**Schedule 1 - Deadline 5 – GLA response to Applicant document 8.02.35 “Applicant Response to the GLA’s Deadline 3 Submissions”**

Schedule 1 – GLA submission Deadline 5

Human Health Receptor Locations (elevated receptors or 'tall buildings')

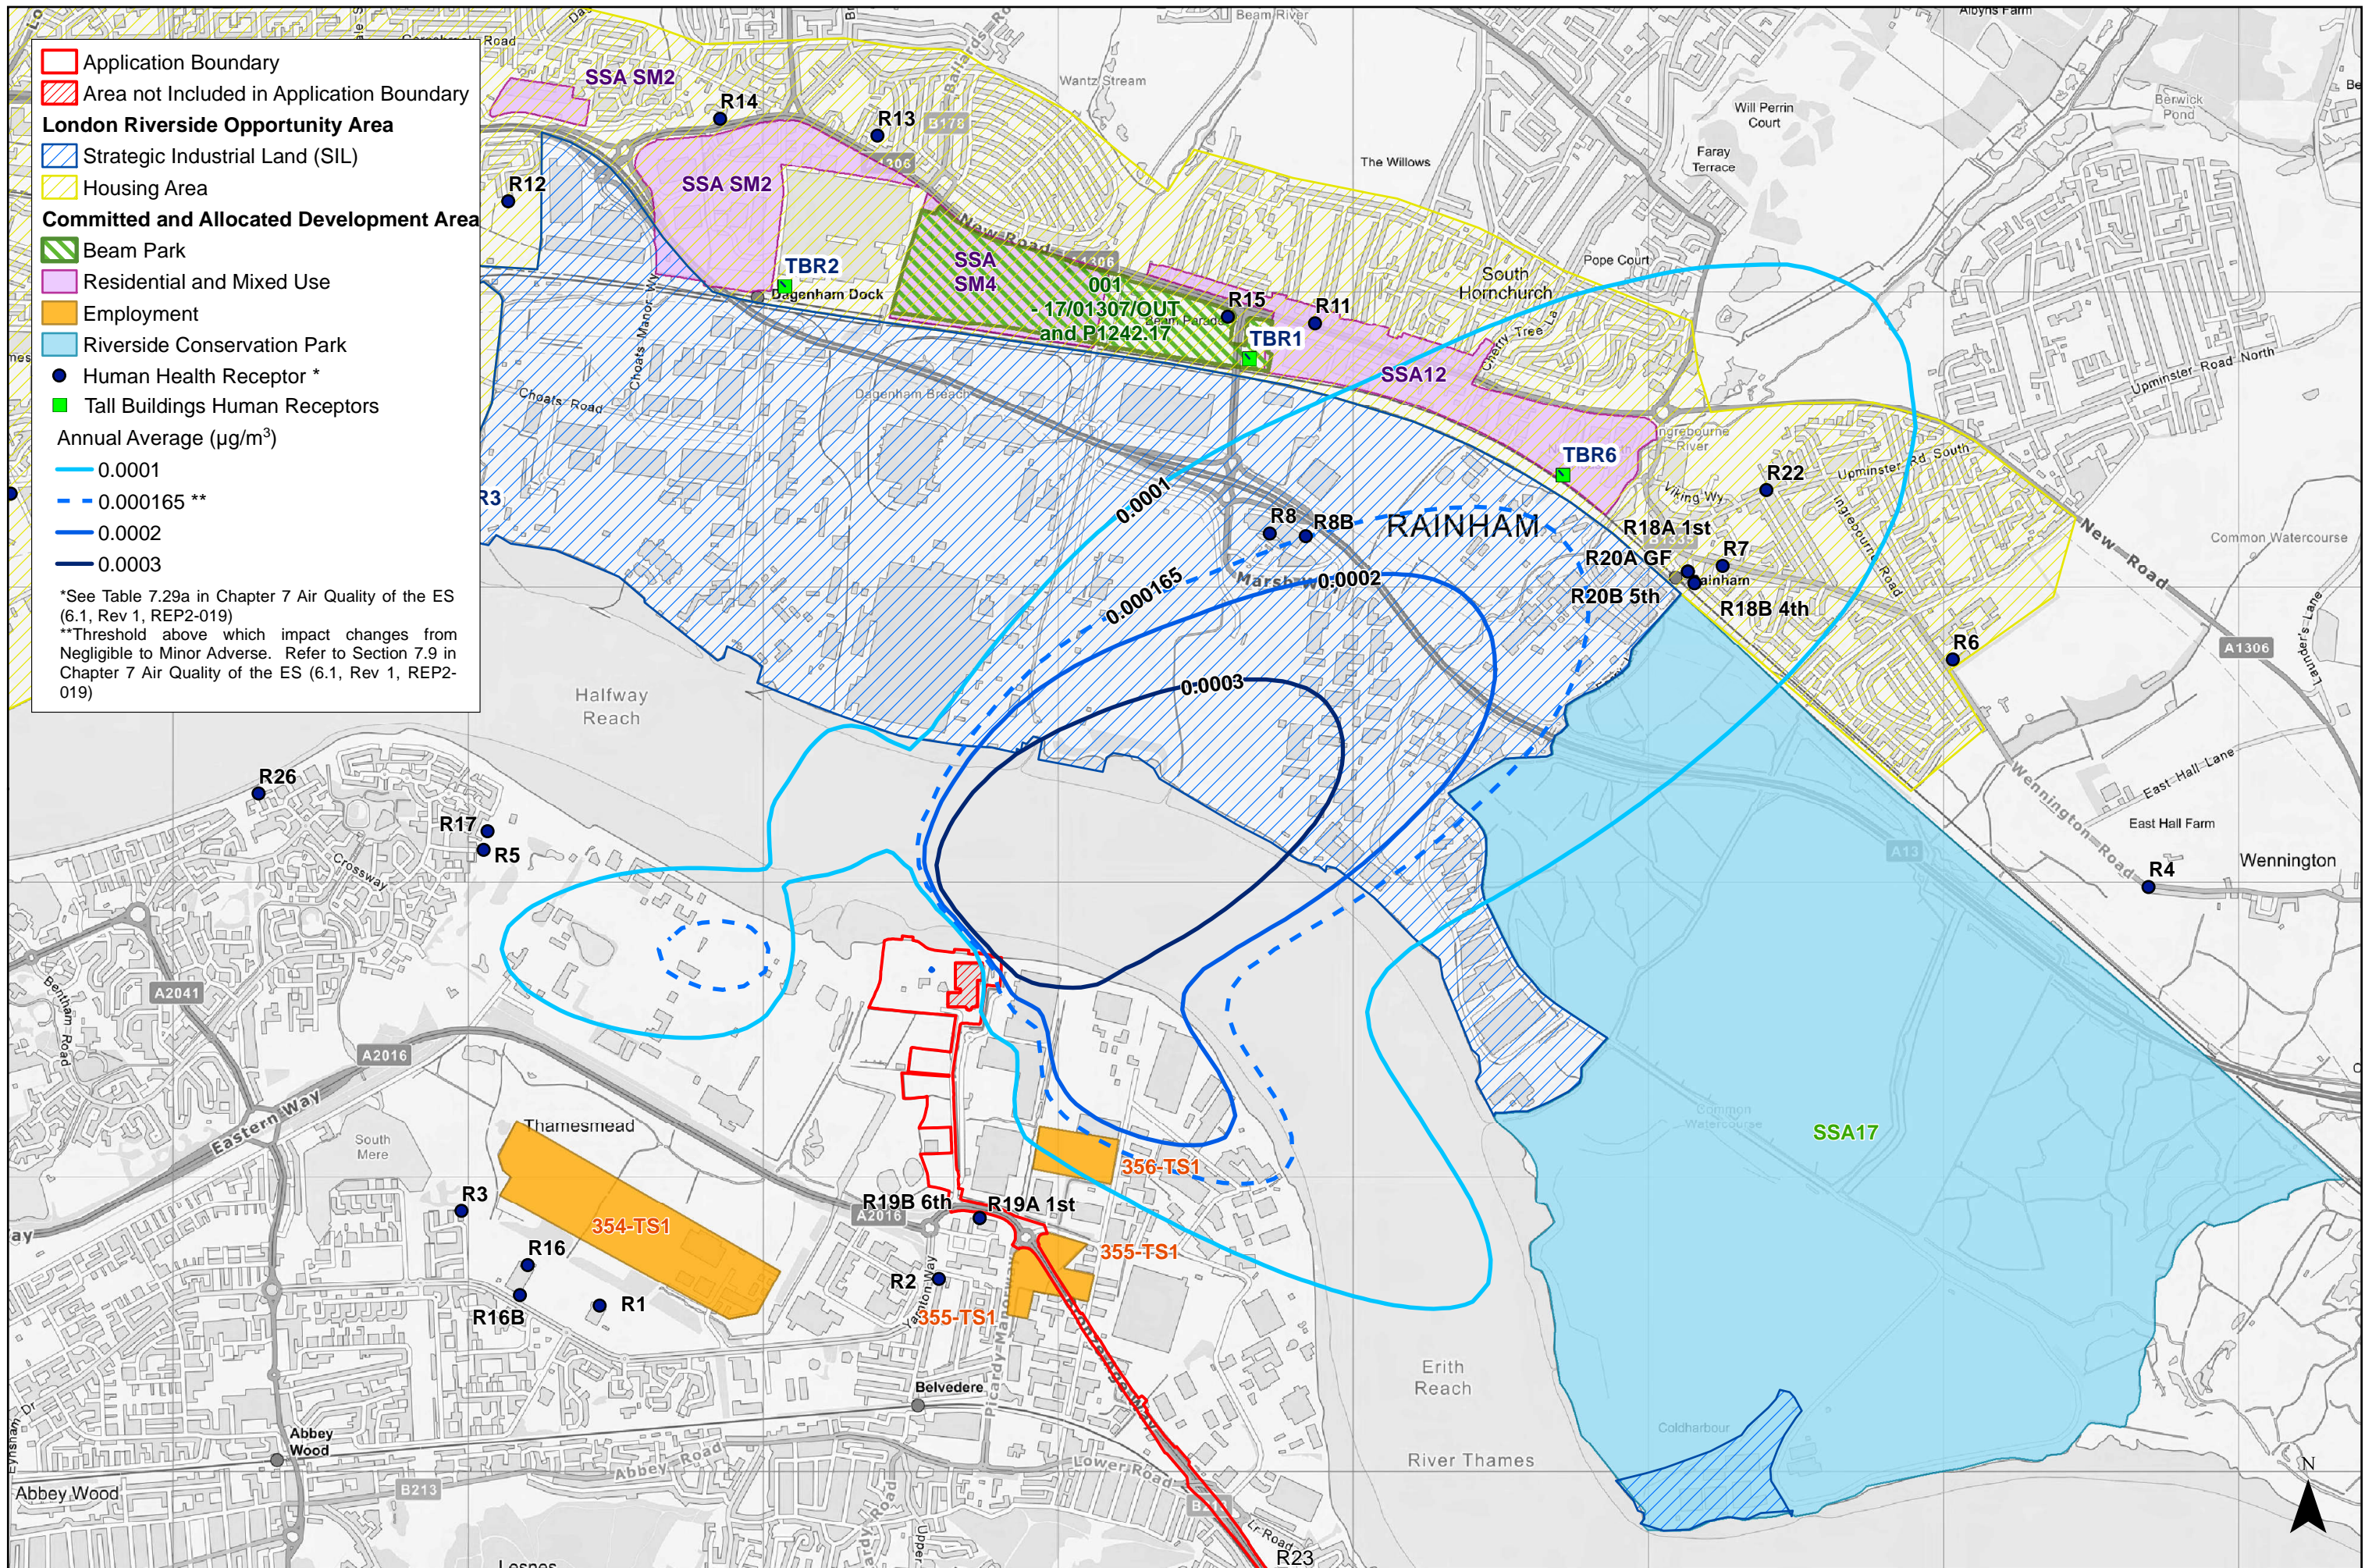
6.5.7 – 6.5.23	GLA response contains a number of other potential locations for high density	75. Noting GLA concern with the impact upon opportunity areas, additional modelling has been undertaken by the Applicant, and this is presented at Table 6.1 of document 8.02.35. However the findings are unclear as the referred to figure showing the receptor locations has been omitted from the

Section	Item	Applicant comment	GLA Comment
		<p>development and tall buildings (in red). These areas are well outside of areas where concentrations at higher levels will be potentially significant. Nevertheless the Applicant has undertaken additional modelling, presented in Table 6.1.</p>	<p>document. Without this figure no comment can be made on whether the results are correctly positioned.</p> <p>76. Nevertheless, the presented results show that the impact on high rise buildings in the selected locations will be greater on higher floors, in some cases substantially so. It also appears that some receptors, which had not previously been explicitly modelled, would be subject to large or very large impacts from metals (e.g. R1 and R6).</p> <p>77. In conclusion the applicant has shown that there are potentially higher impacts on tall buildings within the opportunity area. These impacts are inherent to the REP as designed as they relate to the distance of the receptor to the centre line of the pollutant plume.</p>
